From: Amanda Scholes on behalf of Planning.Responses
Sent: 15 December 2021 08:07
To: Planning Scanning
Subject: FW: Planning Consultation on: P/158/21/RES

Engineers Comments Regarding Surface Water Drainage

Application No: P/158/21/RES
Registered: 19th November 2021
Site Address: Land West of Pagham Road Pagham
Grid Reference: 488924 98195
Description of Works: Approval of reserved matters (layout, scale, appearance and landscaping) following outline consent P/140/16/OUT for the 'local centre' parcel which comprises of retail, community and commercial uses, 20 No residential apartments and a 70 bed care home (alternative scheme to P/155/21/RES).

Drawing Title:
Proposed Soft Landscape Sheet 1 of 3

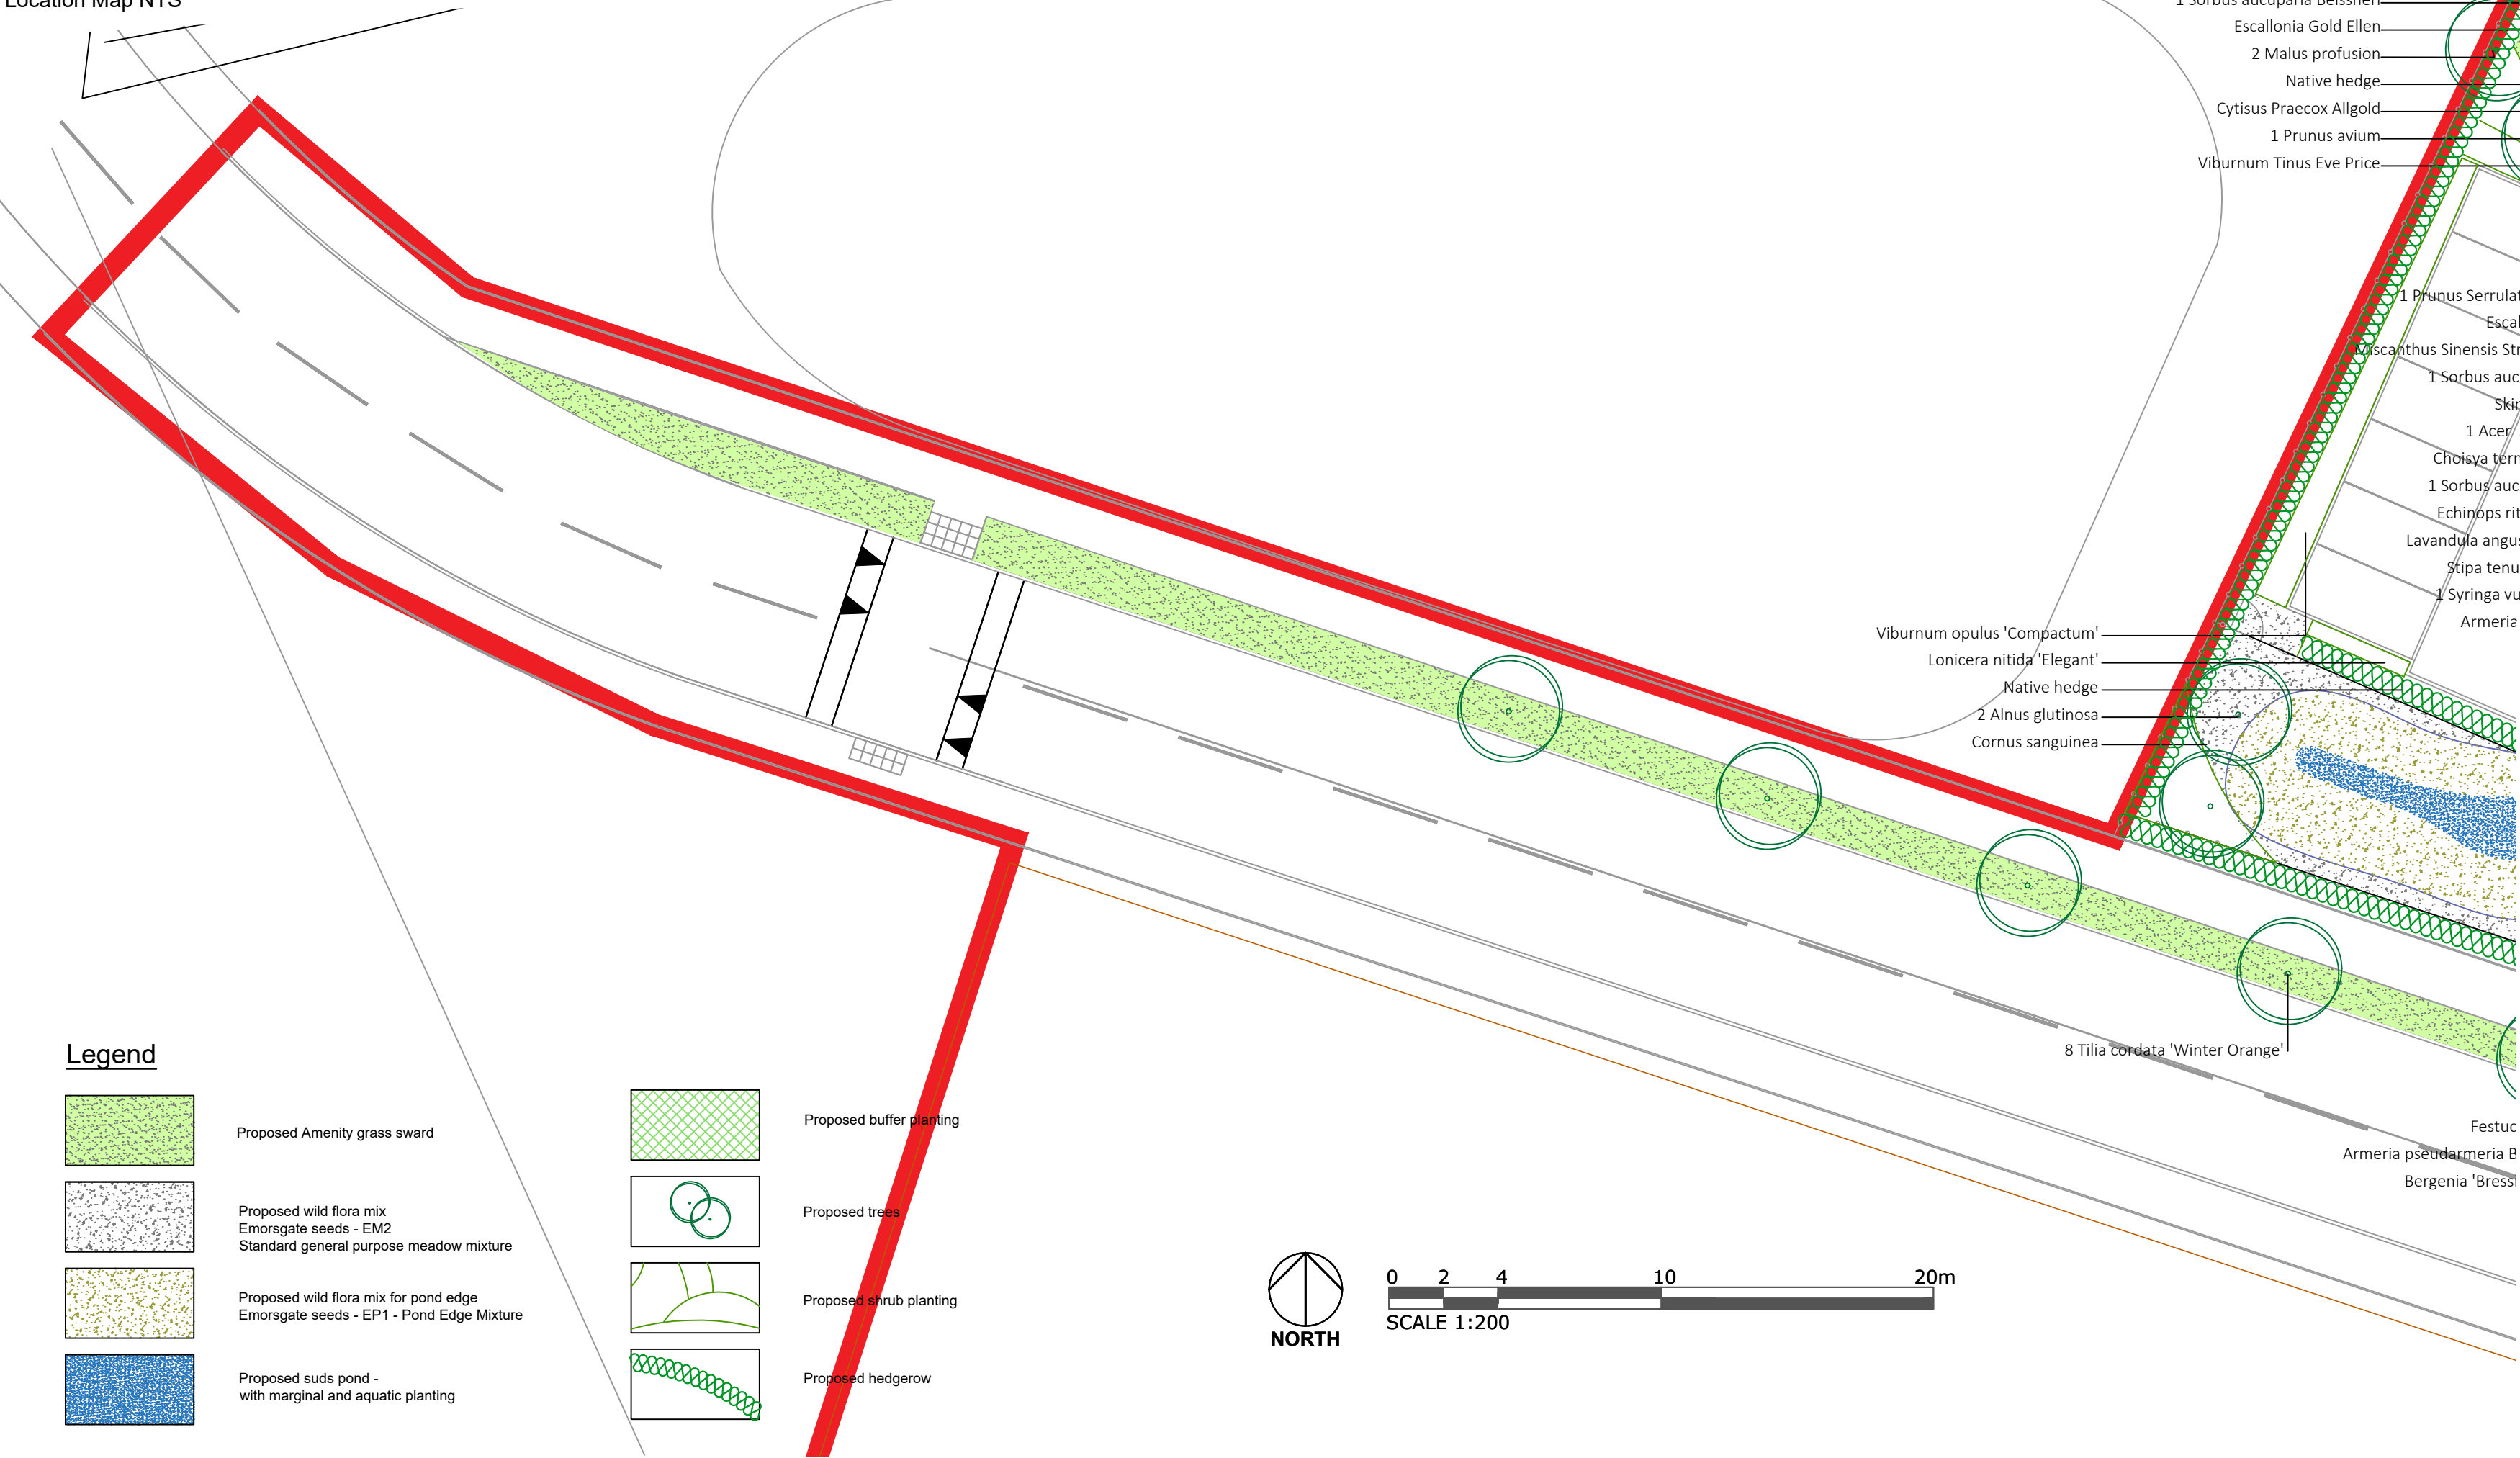
The proposed layout has a SuDS basin, buildings, trees, and fence lines proposed within very close proximity to the watercourses. All of these features must be at least 3m away from the top of bank of watercourse.

3. FEH2013 rainfall data must be applied to calculations.
4. Surcharged outfalls should be applied to calculations. The surcharged outfall levels should be set to adjacent top of bank level.
5. A minimum of two perpendicular cross sections per basin must be supplied.
6. We note that a number of trees are proposed in close proximity to drainage features. Root potential areas must not conflict with surface water drainage features.
